| Application number: 2025/90236   |  |
| What is the application for?:    | Erection of garage incorporating garden store and music room and formation of dr |
| Address of the site or building: | Dearne Grange Cottage, Park Head Lane, Birds Edge, Huddersfield, HD8 8YA         |

DRAWING DESCRIPTION
GARAGE SCHEME
EXISTING AND PROPOSED

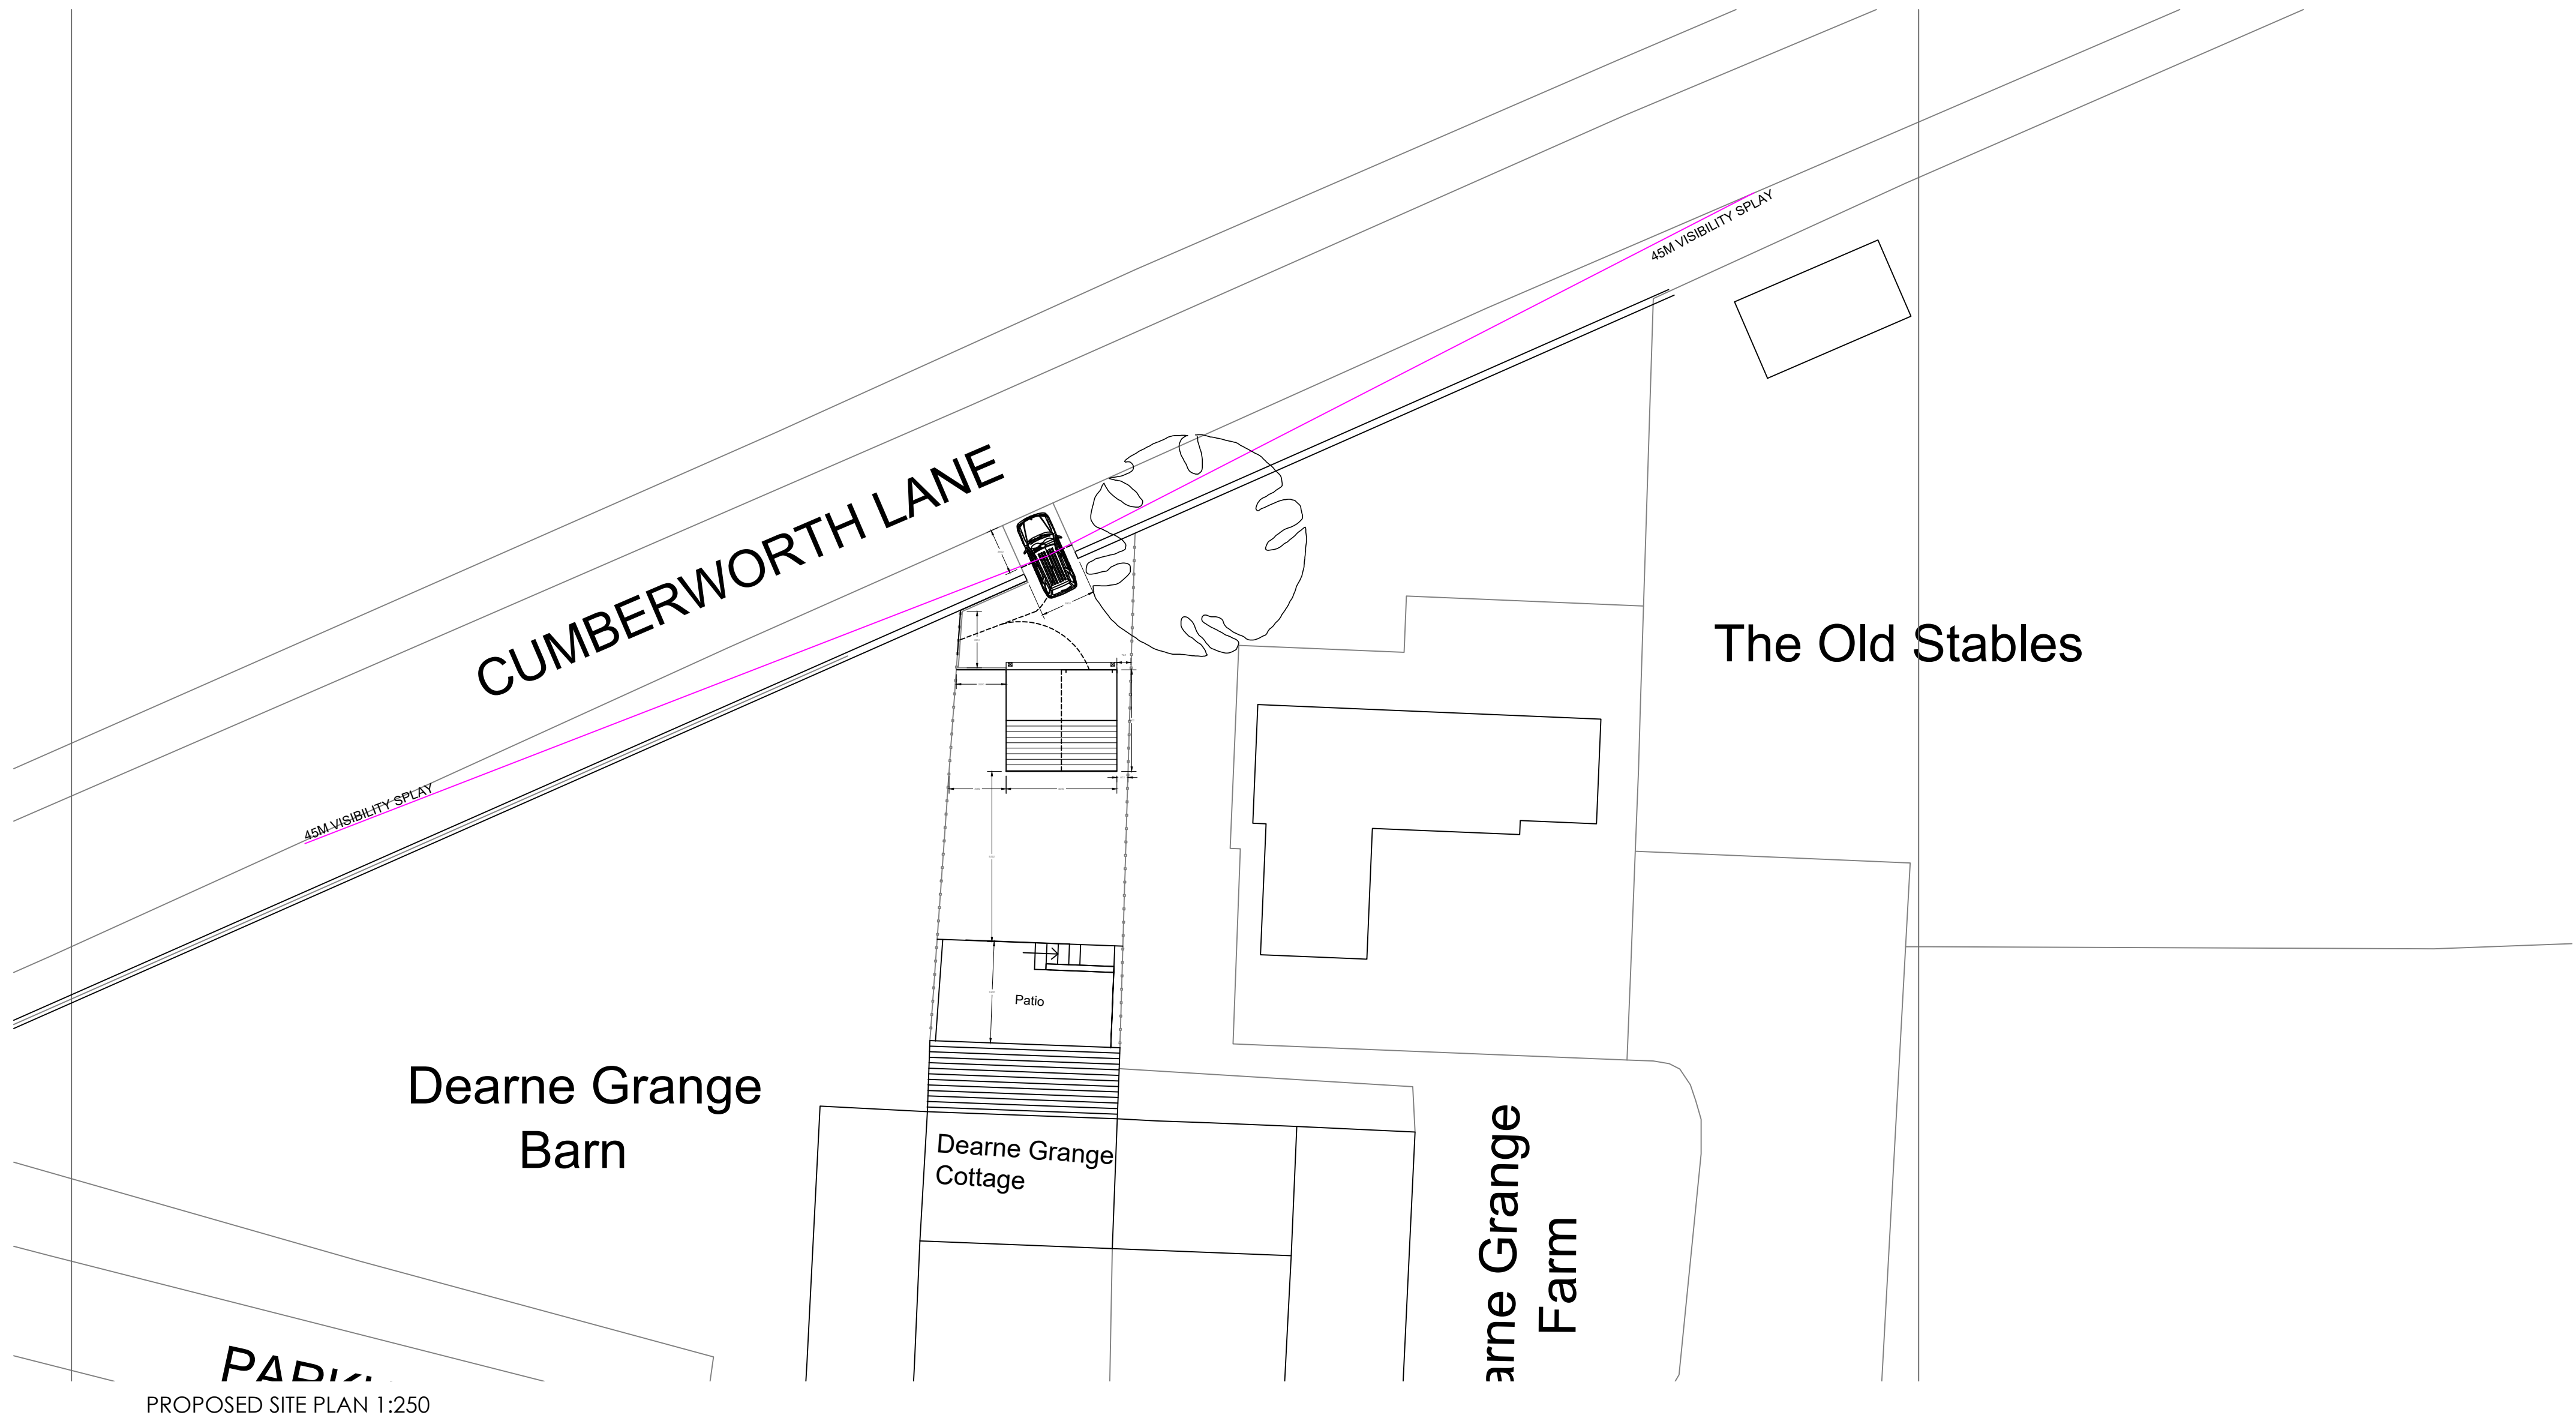
| <p>I do not think it safe to allow an access from the garage onto the main road.<br/>A large amount of vehicles use this road including the heavy goods vehicles taking the rat run up Carr Hill Road and along to 5 lane ends.<br/>It is also just after the bend so visibility would be restricted for traffic approaching from 5 lane ends to be able to see the exit.</p> |     |
